CITY OF PORTLAND

has permission to PRUD 12 unit condominium building 3 units

AT 118-122 Starbird Rd

**Job Name:** Starbird Condominiums

# STAIR DETAIL

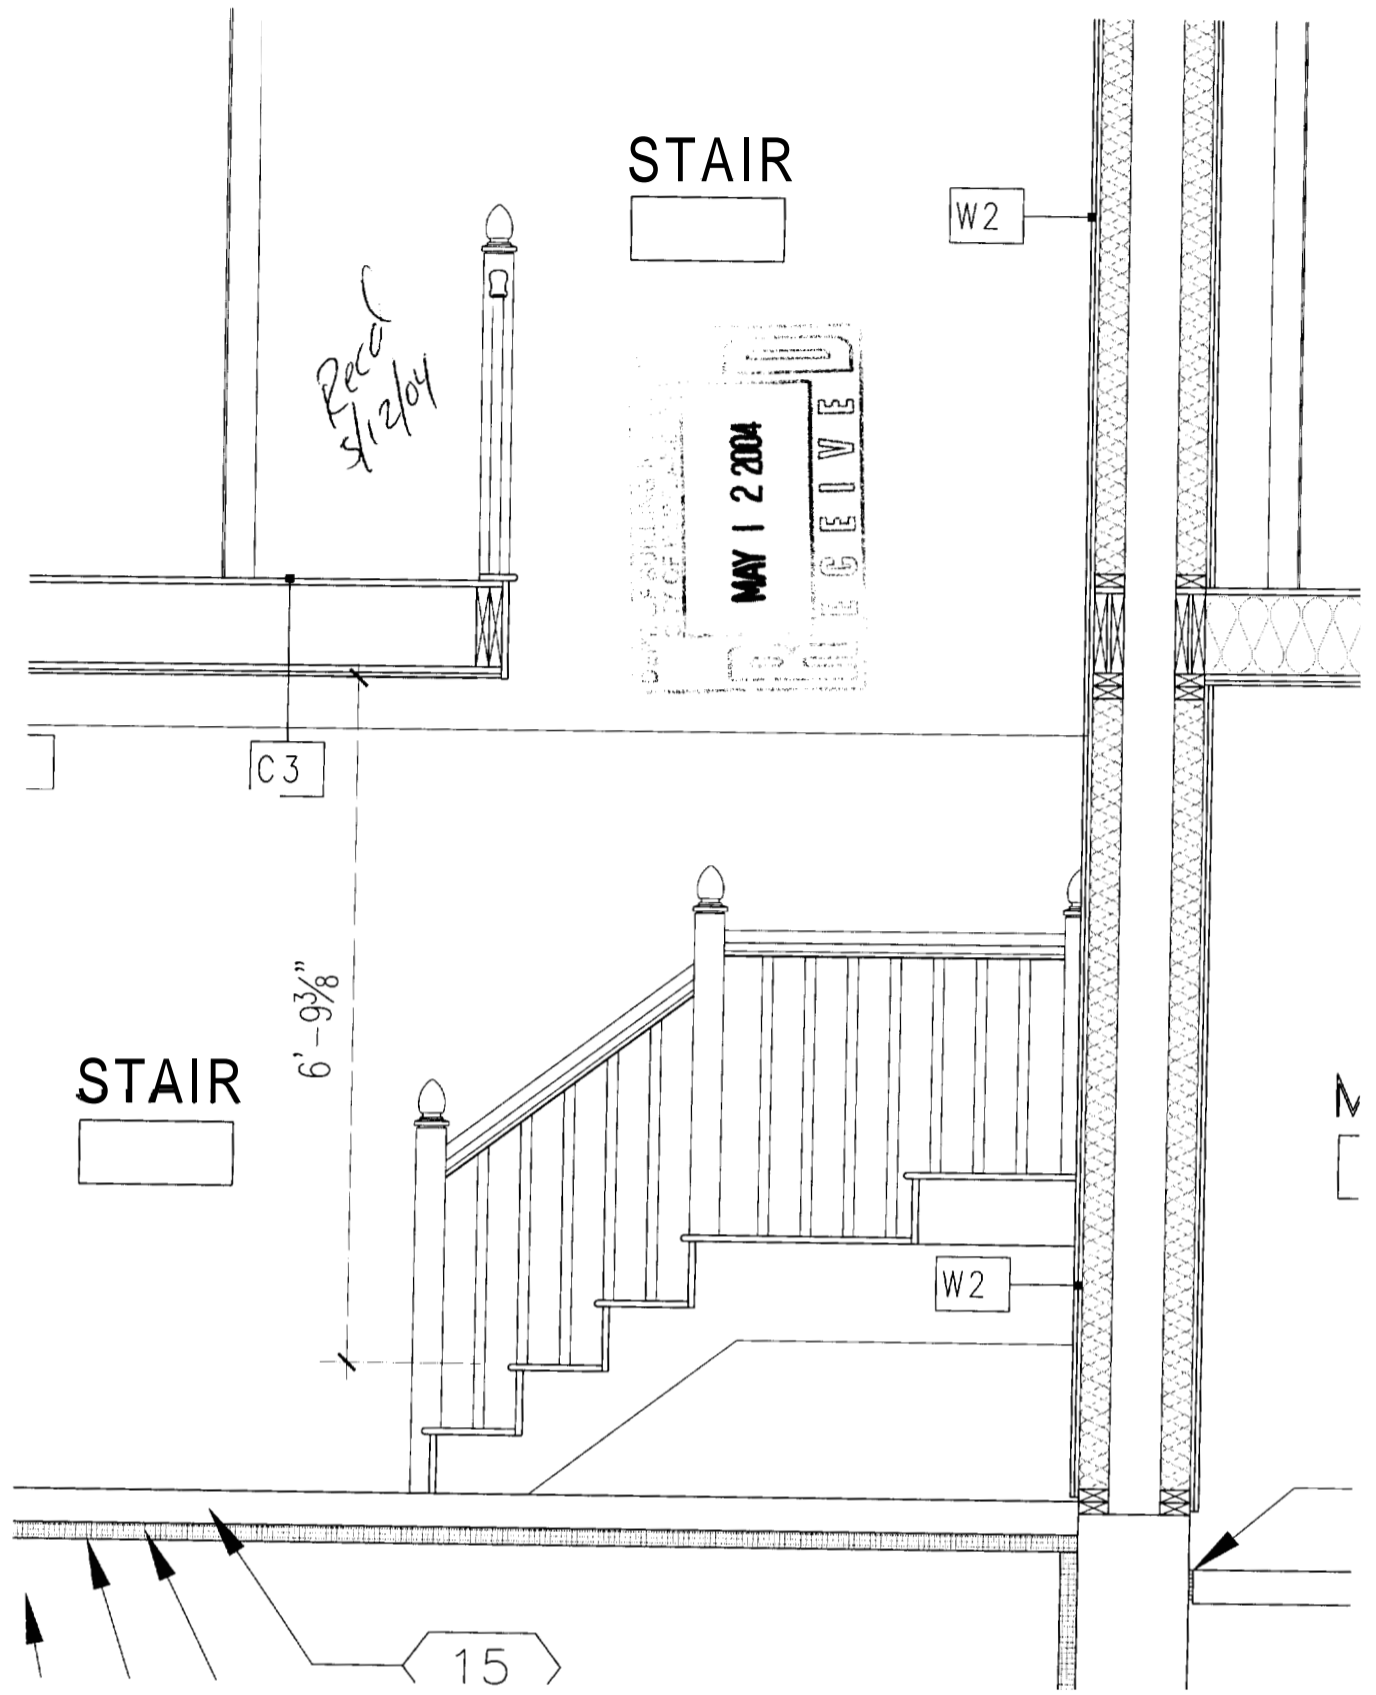
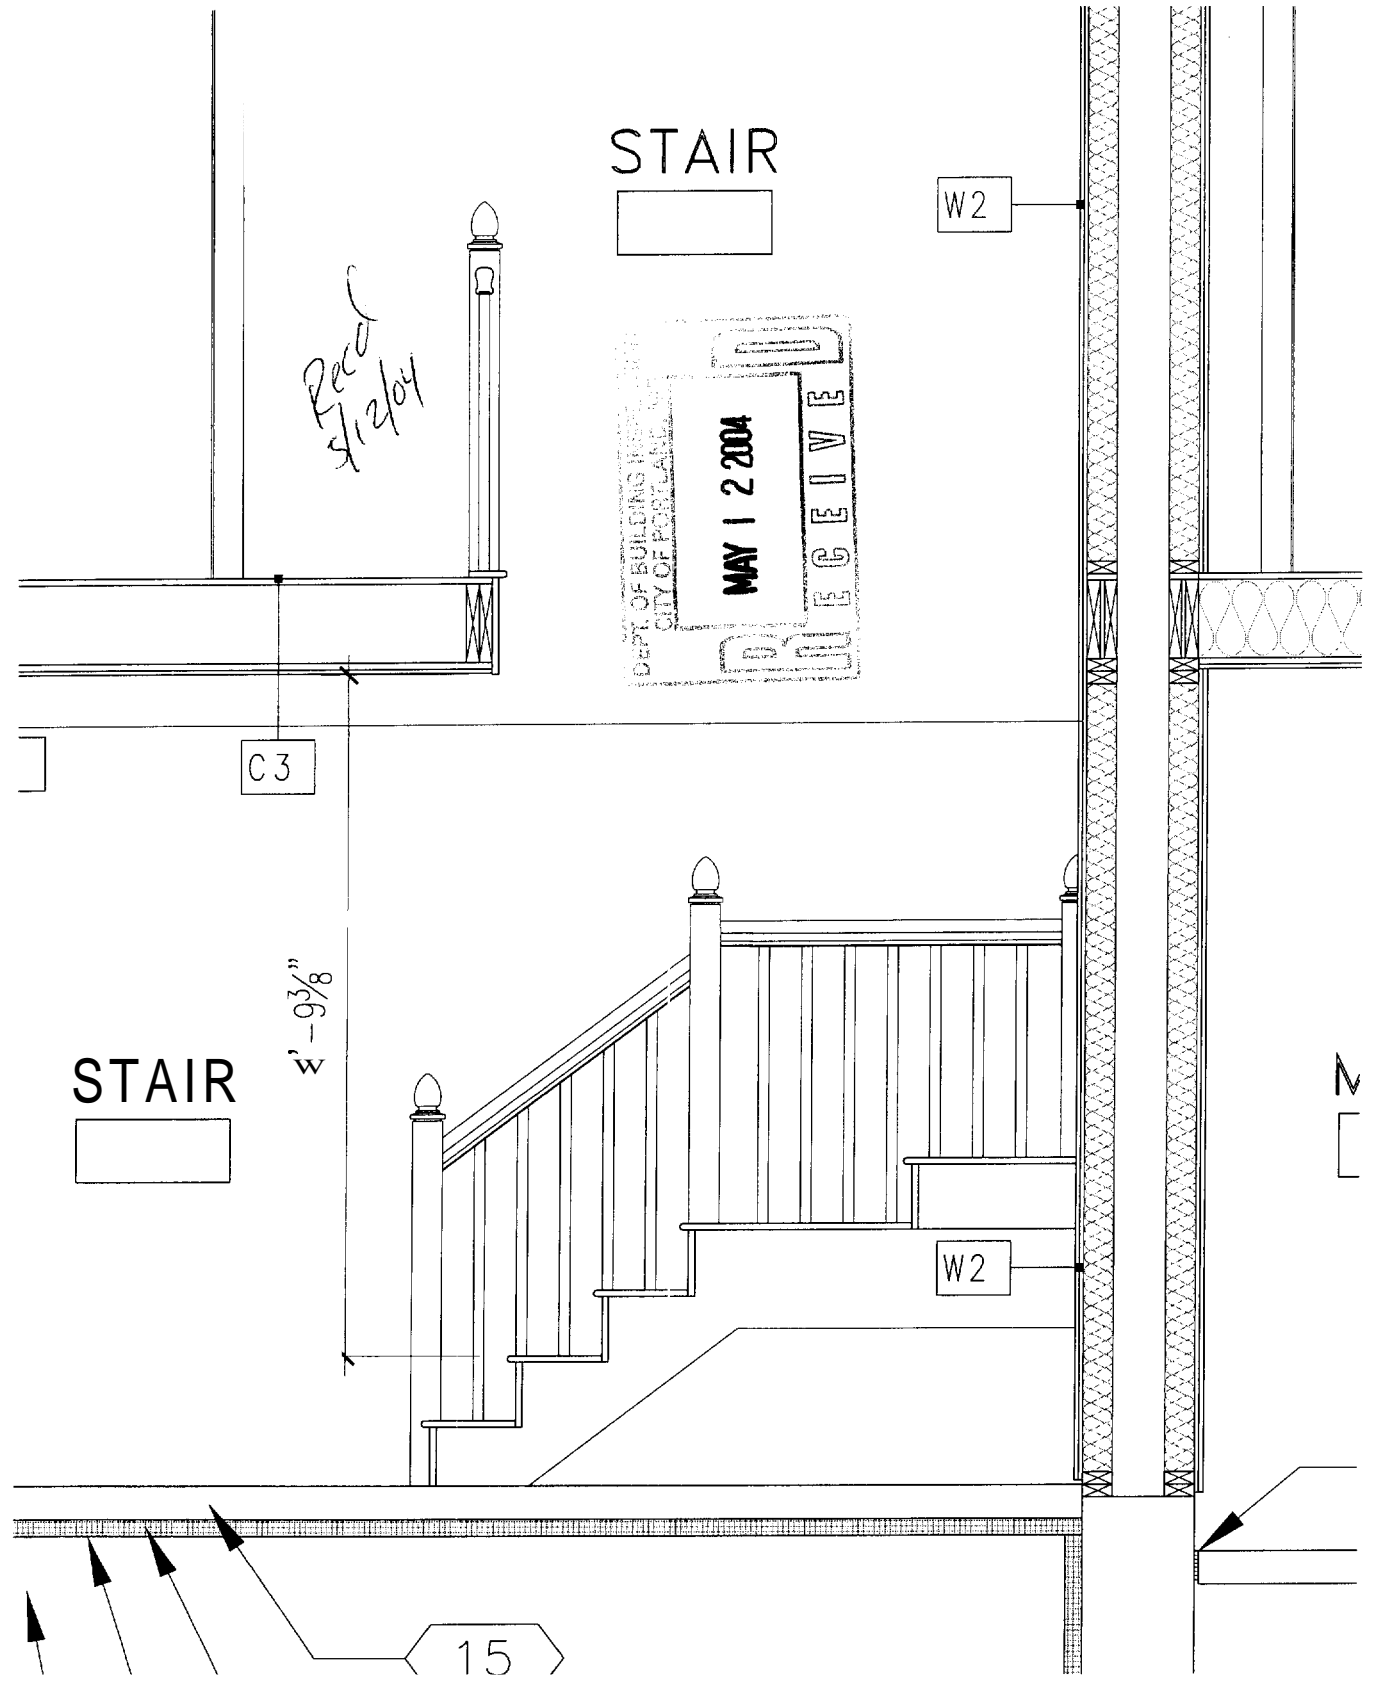
4/30/2004-tmm: need stair details, attic acces info, third floor weight calc's for hvac equipment, smoke det locations, clearance in chase, fire blocking in tenant separating walls and structural support of walls, - faxed info to builder.

5/12/2004-tmm: rec'd above info - okto issue
